# KITTITAS COUNTY

### MEMORANDUM

DATE: December 6, 2019

SUBJECT: Keno SPF-19-00004

**KENO AGRICULTURAL SHORT PLAT
PART OF SECTION 29, T. 18 N., R. 20 E., W.M.
KITITAS COUNTY, WASHINGTON**

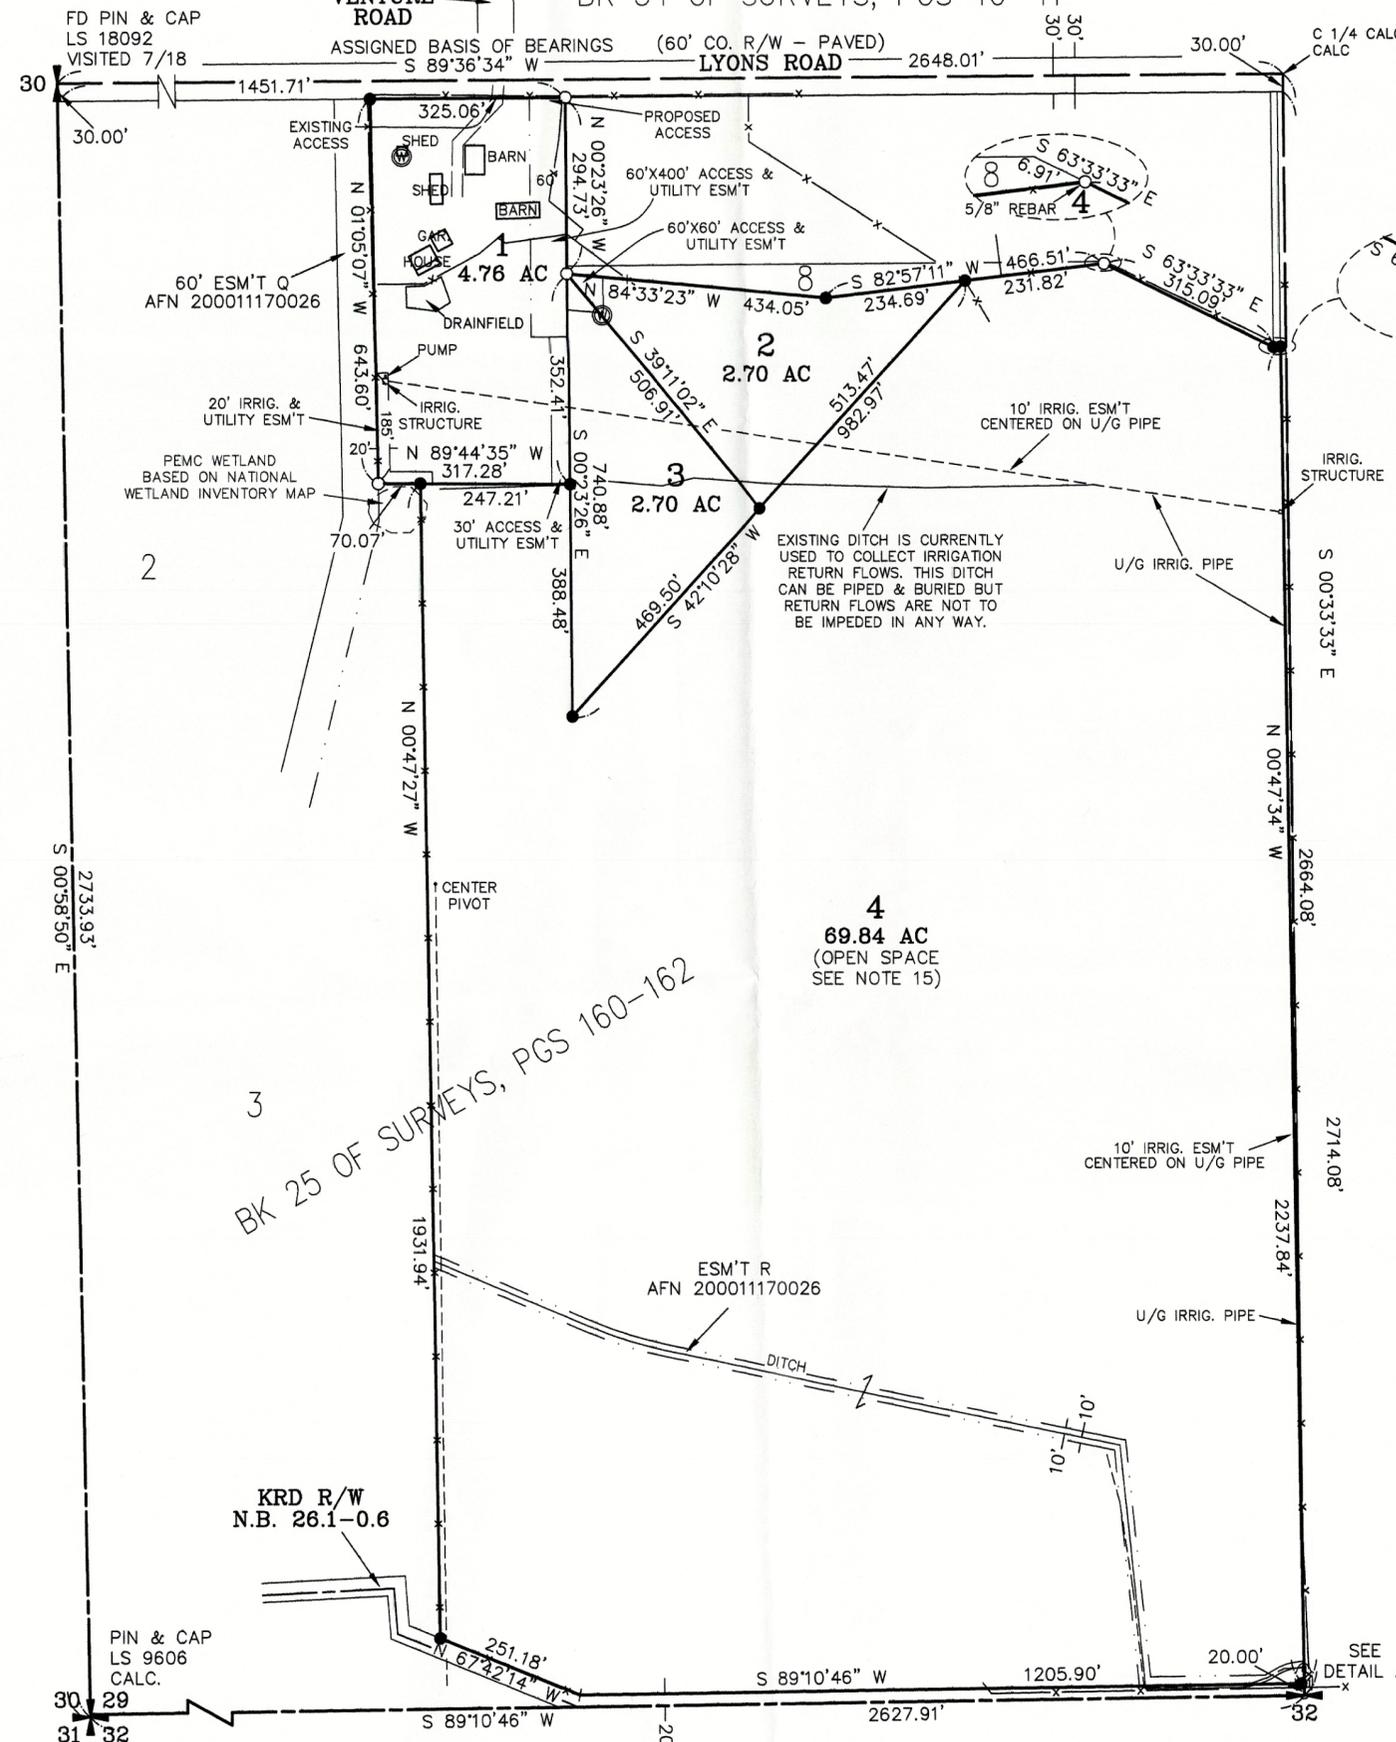
1. There are 6 easement notes shown that do not reference a recording number. As it is presumed that these are creating new easements, the term "herein dedicated" (or similar) shall be shown on the easement notation.
2. The irrigation easement located at the southwest corner of Parcel 1 is not retraceable as shown. Please include sufficient information so that it can be mathematically retraced.
3. The bearing shown identifying the westernmost line of Parcel 3 is partially obscured by the corner symbol.
4. Please reference the adjacent Survey Bk 25 of Surveys, Page 151.
